**Consultation Response from KC,
Lead Local Flood Authority**

2025/90372 Land at, Edgerton Road, Edgerton, Huddersfield, HD3 3AA

Discharge of details reserved by conditions 6, 7, 8, 9 (drainage), 11 (lighting scheme), 14 (Arboricultural Method Statement), 19 (Construction Method Statement), 21 (estate road), 22 (highway works), 23 (boundary treatments) on previous permission 2017/91916 for variation condition 23 (highway works) on previous permission 2014/93014 (APP/Z4718/W/15/3002523) for outline application for residential development comprising of 41 dwellings plus associated works (within a Conservation Area)

Date Responded: 3rd August 2025

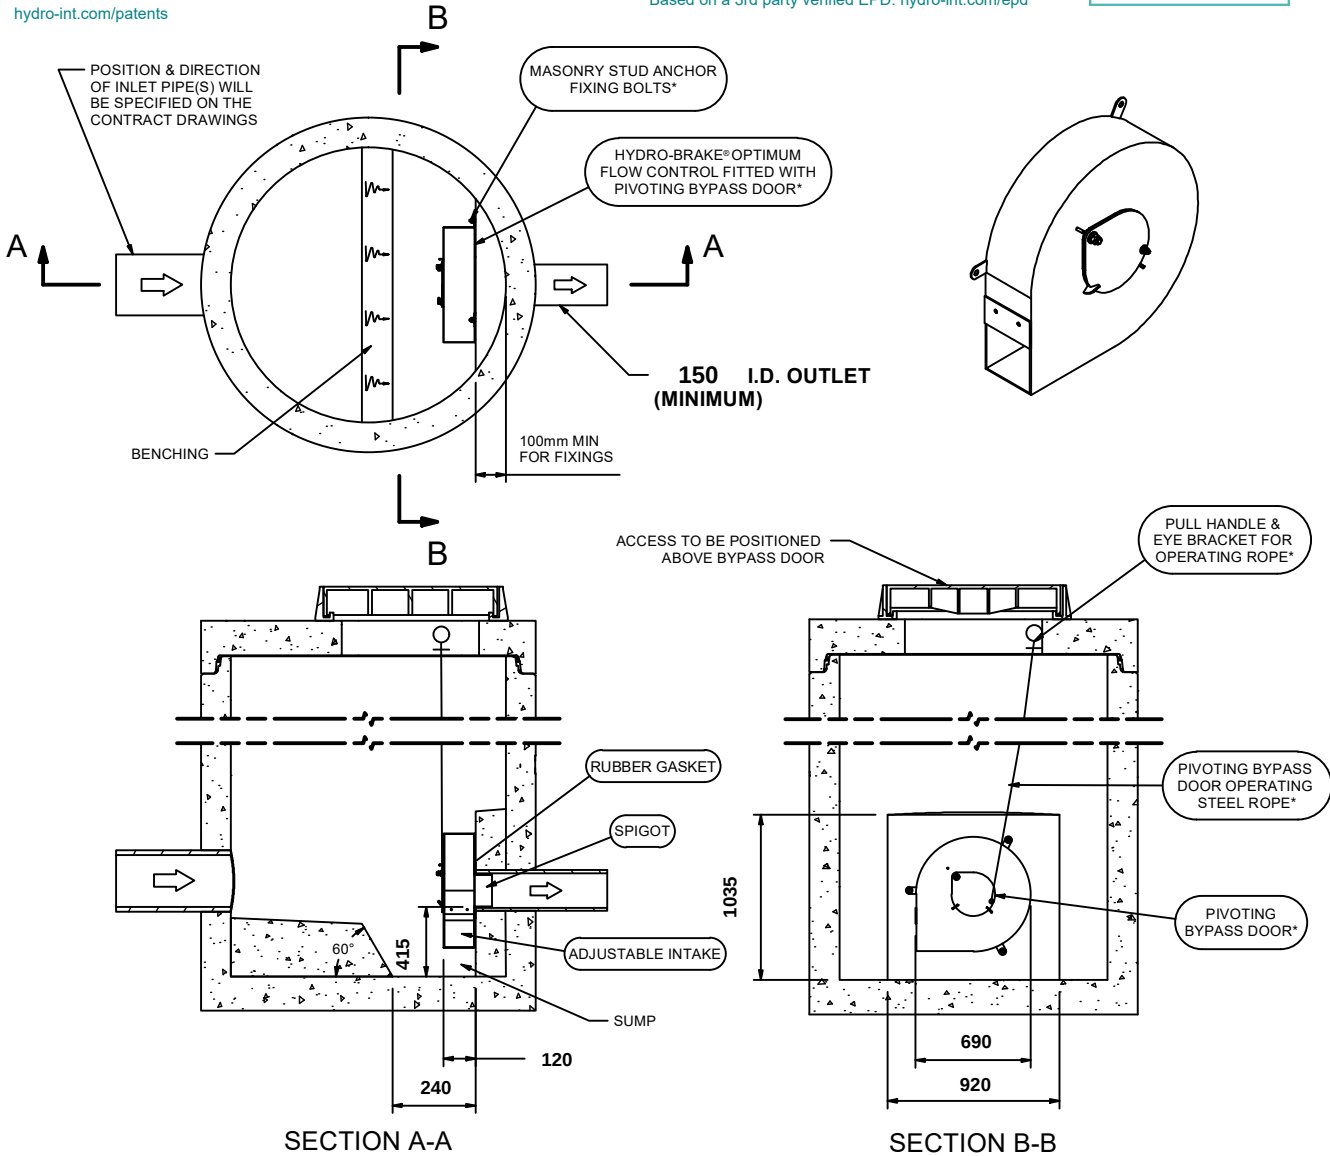
Previous submission showed 4 flow controls and four attenuation tanks. Some of the drawings related to this are still active as part of this application. Layout drawings have subsequently been submitted that show two pre cast concrete tanks but only one flow control. From the levels given, the upper tank and many of the oversized pipes will not fill if this was the case.

There are no detailed drawings of the tanks, cross sections, plans, manufacturing type etc. No flow control manhole details have been submitted. No flow control designs have been submitted.

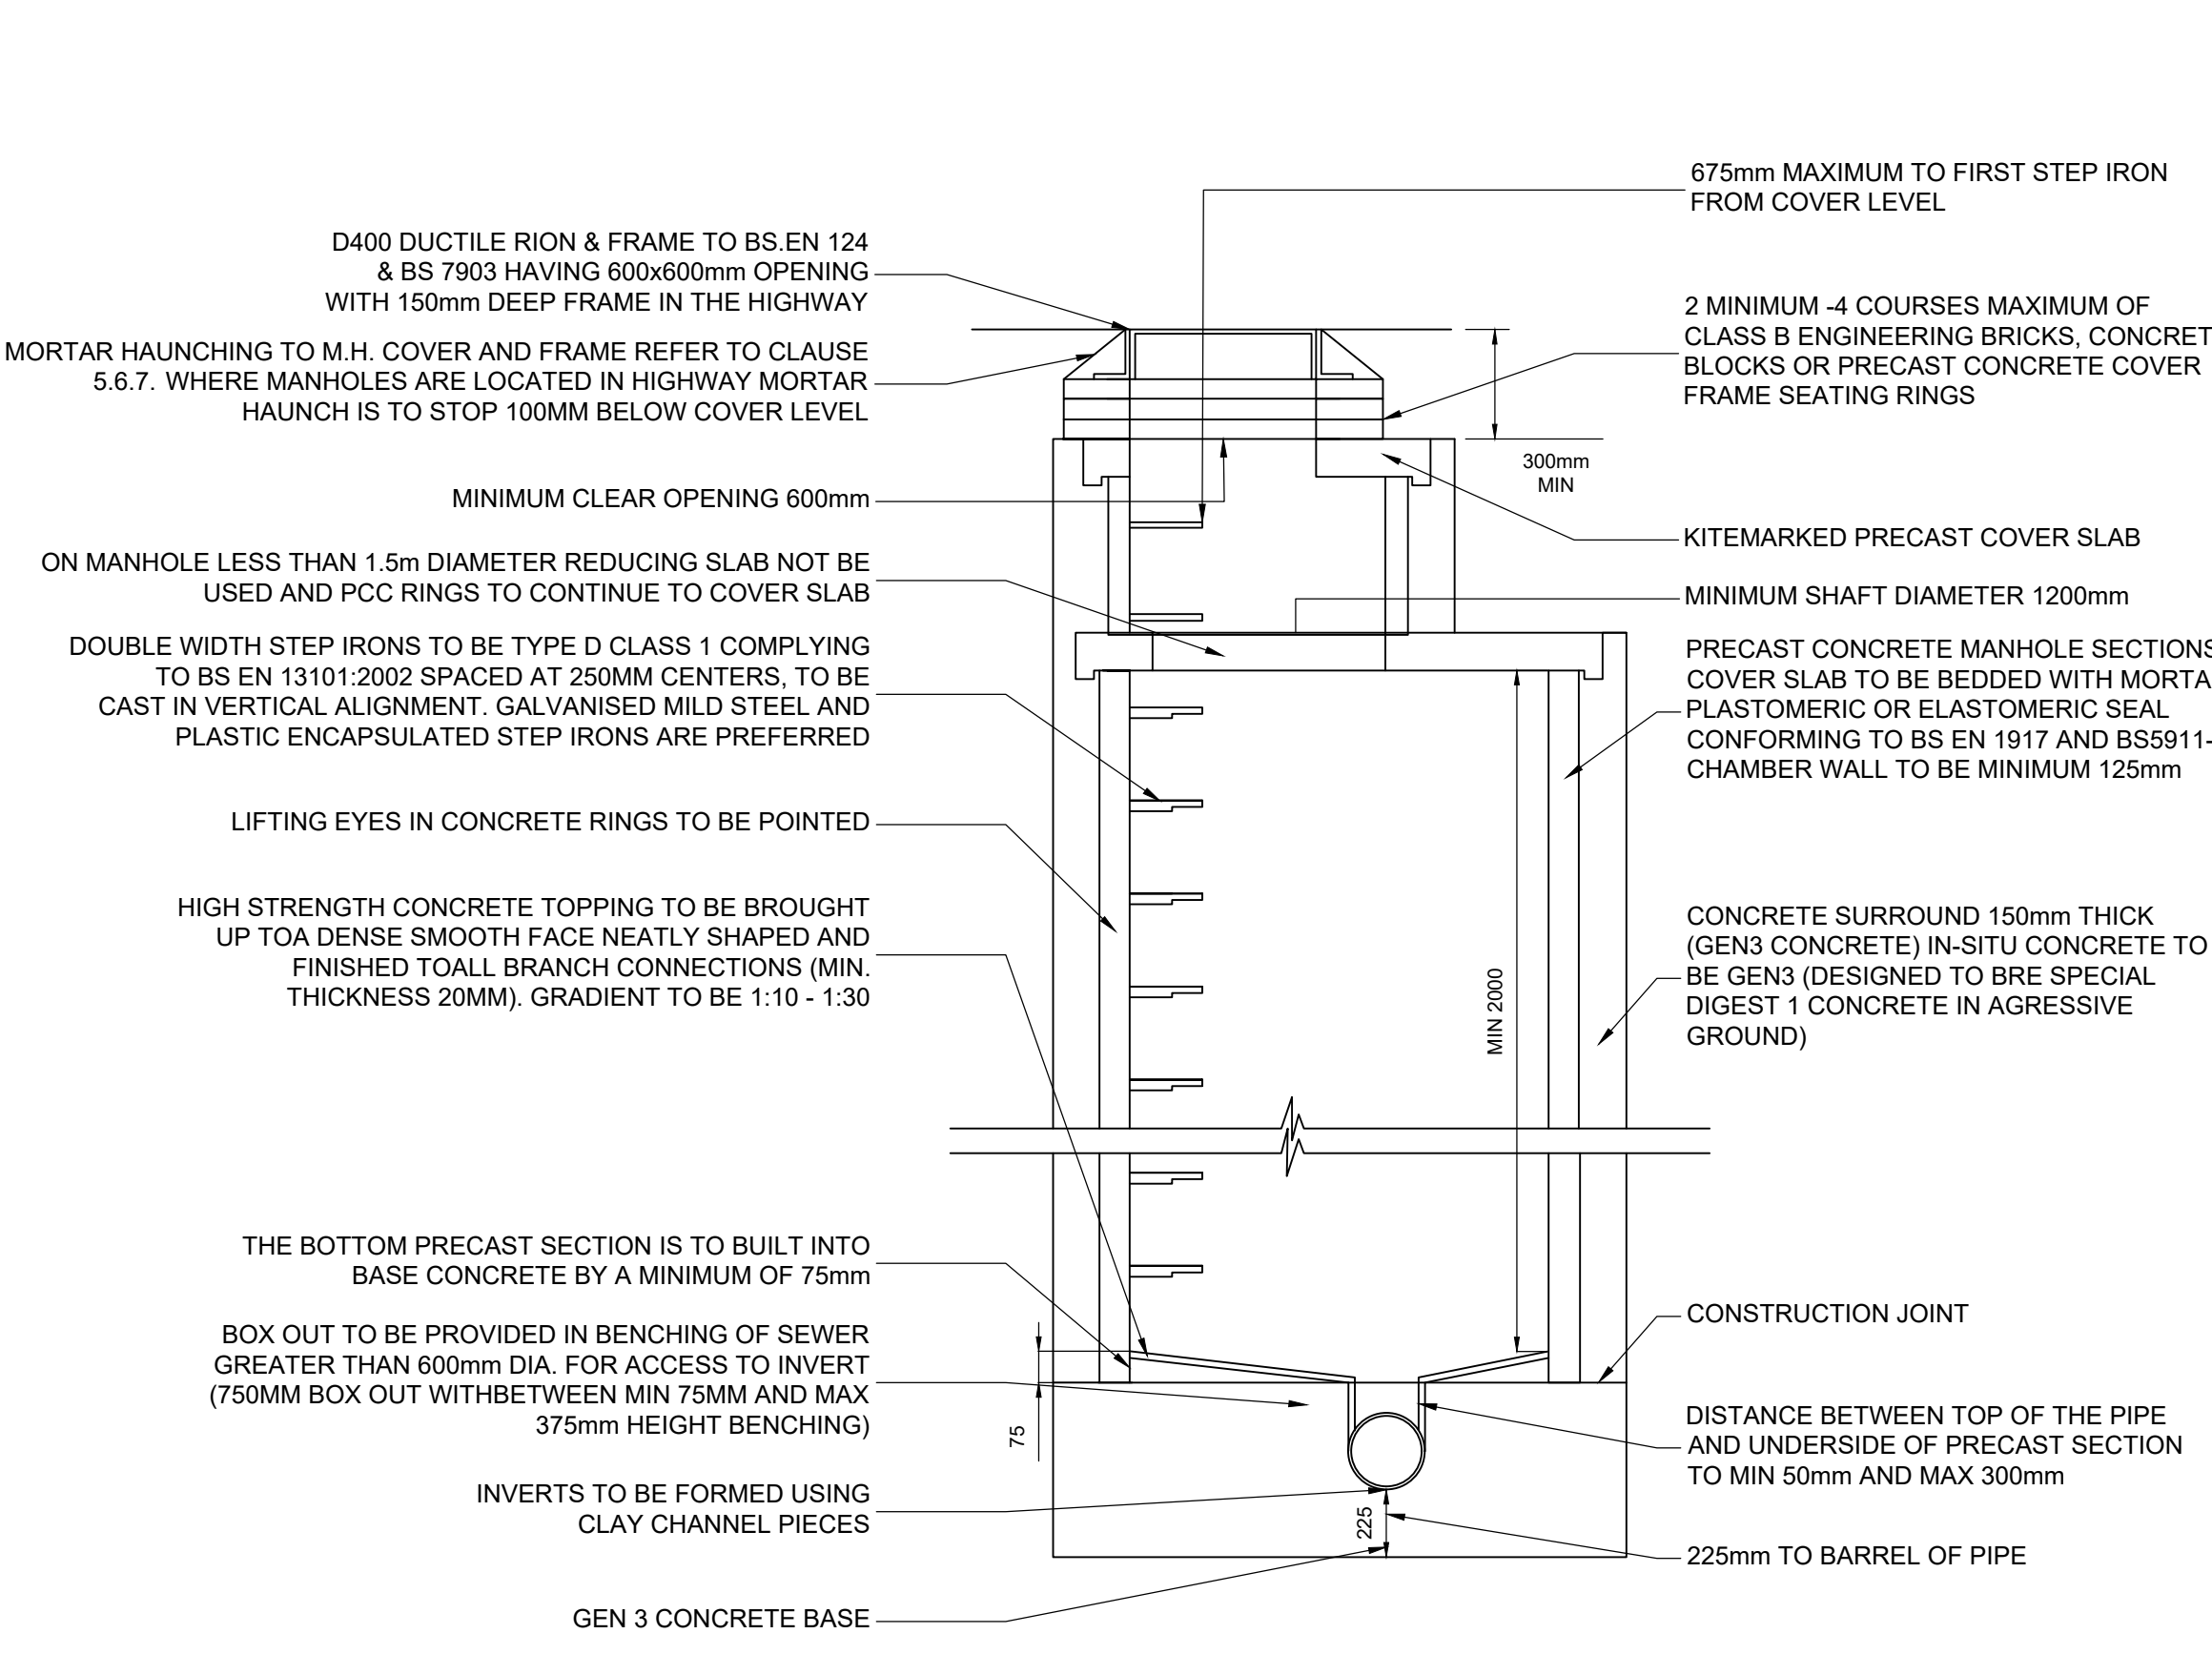
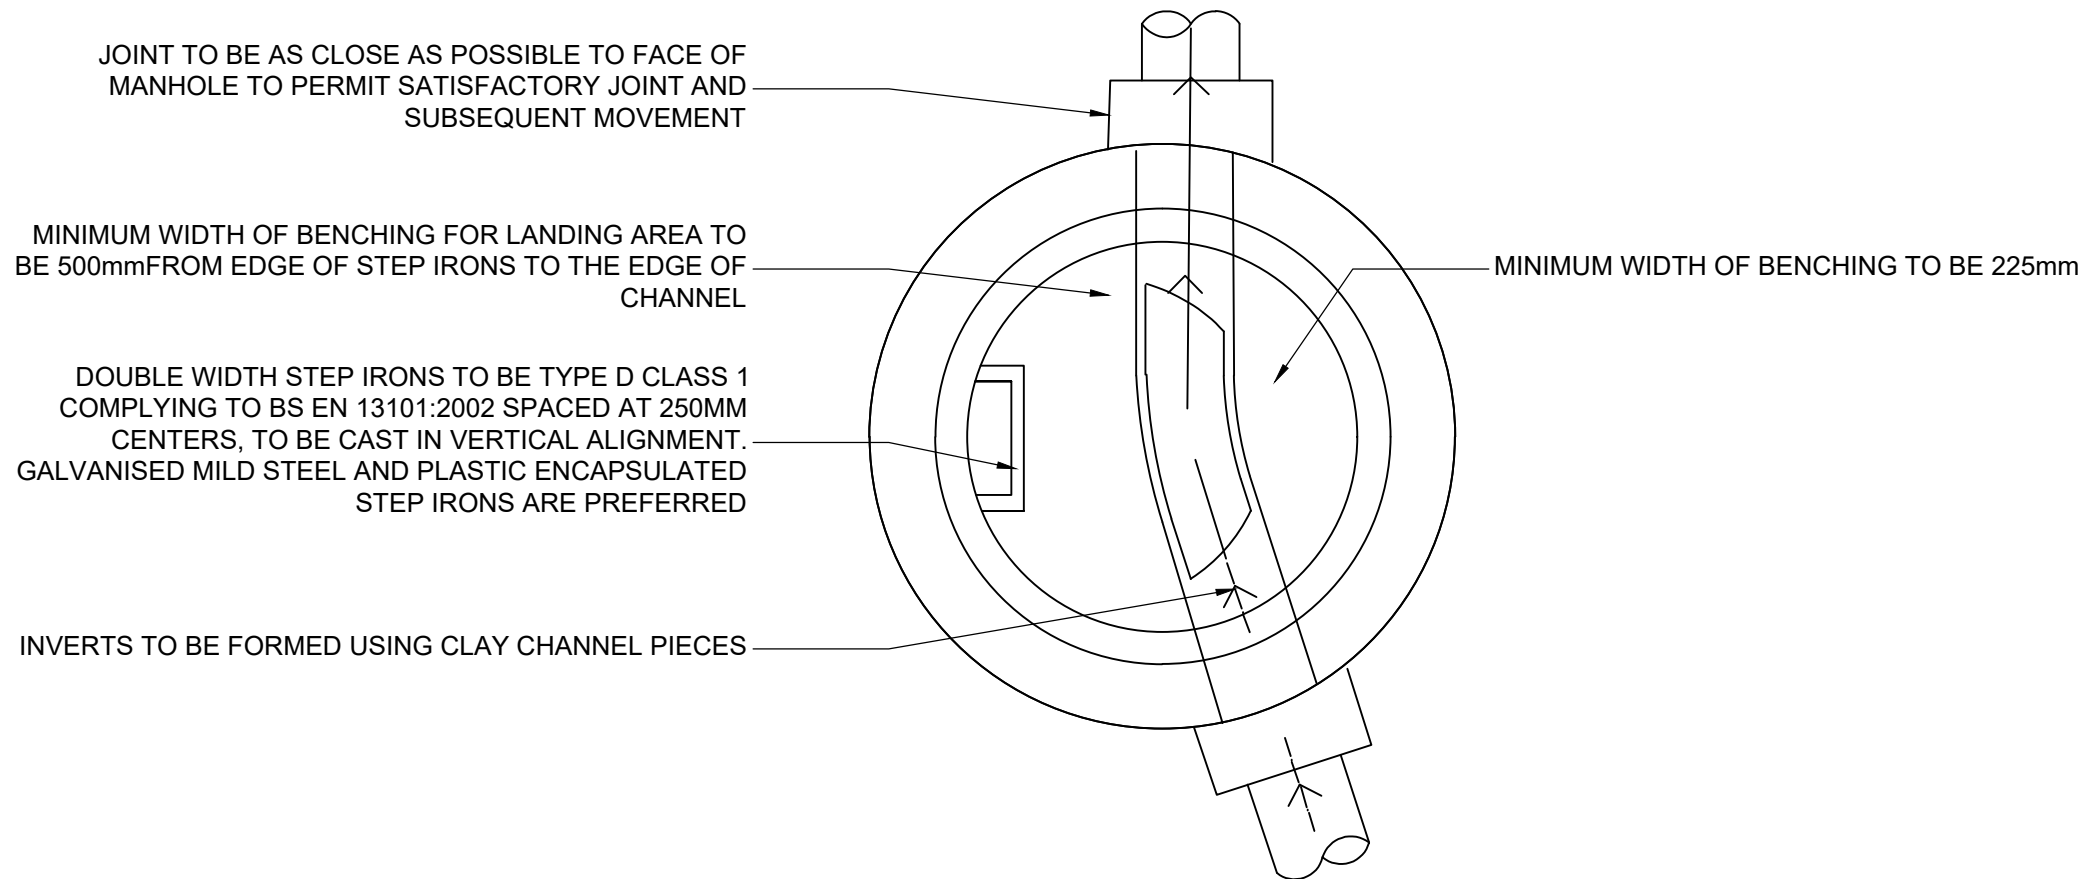
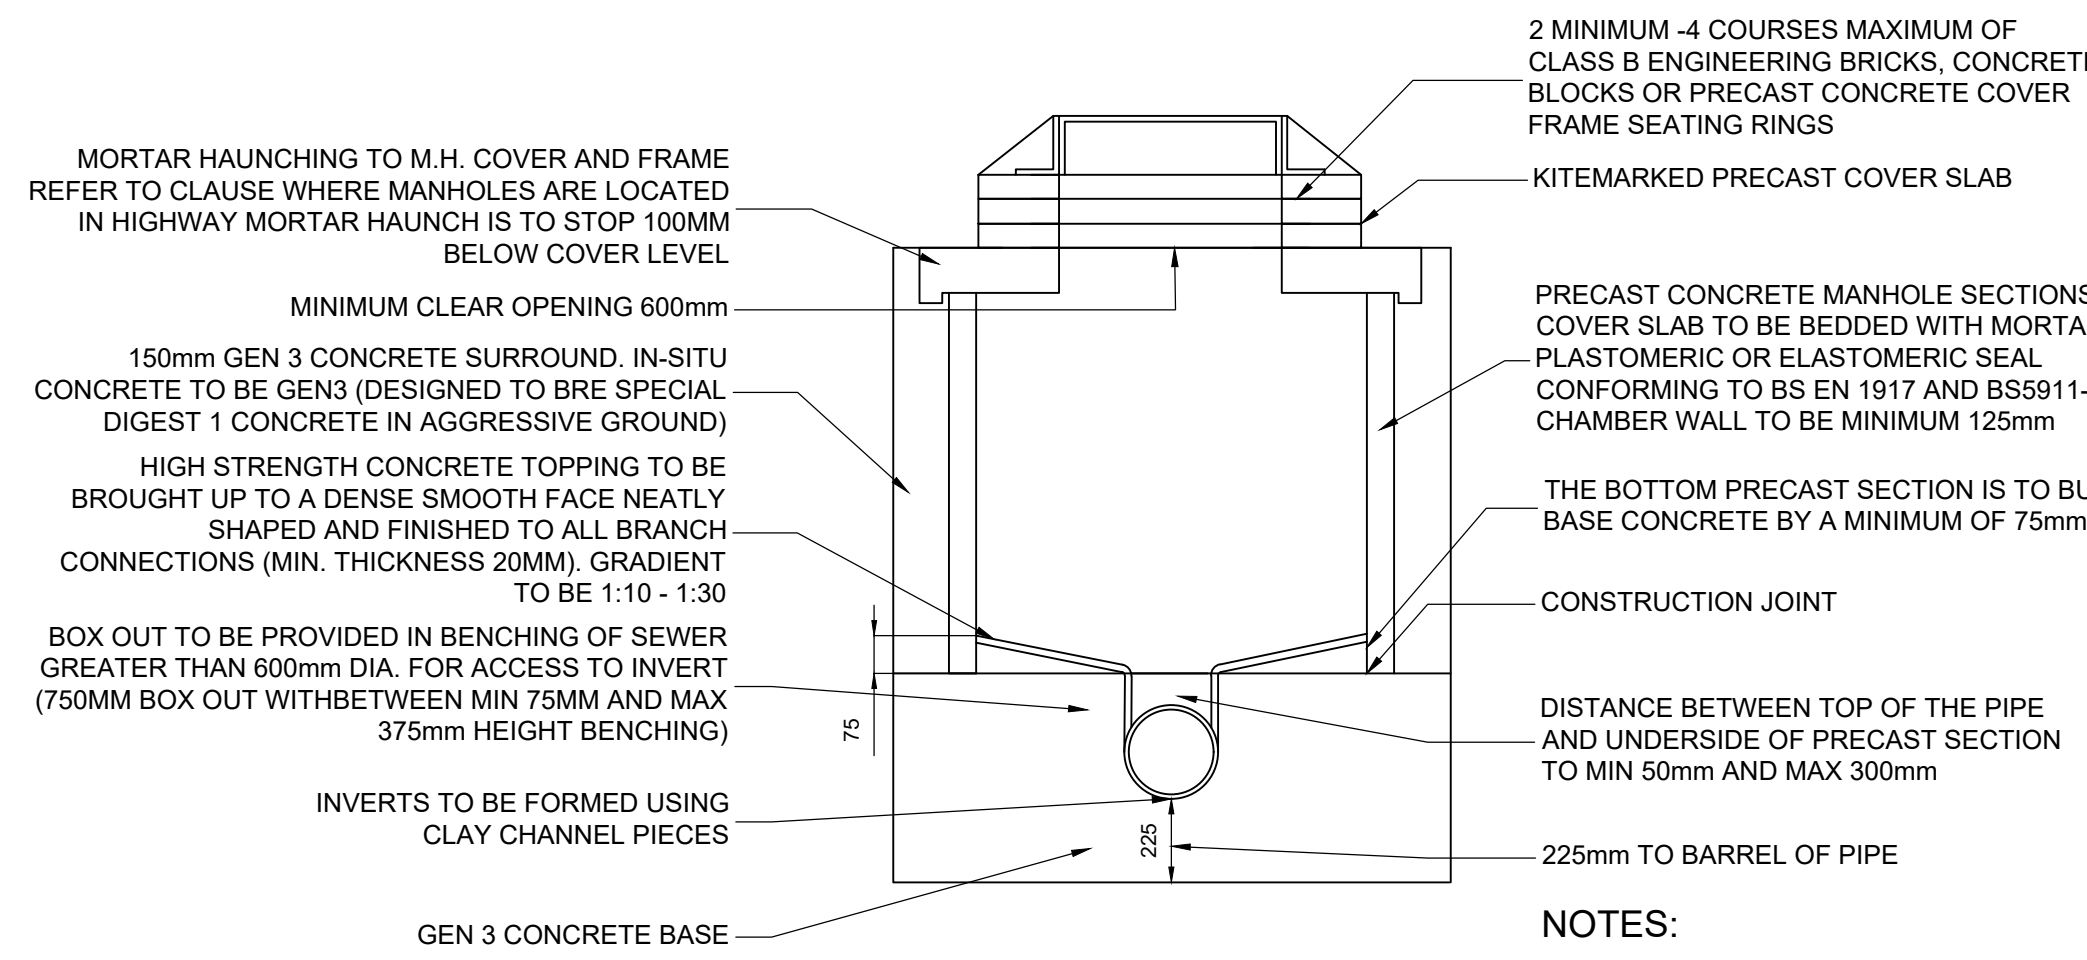
There are no updated longitudinal sections, and the original ones do not show pipe sizes or indicate where backdrop manholes are located.
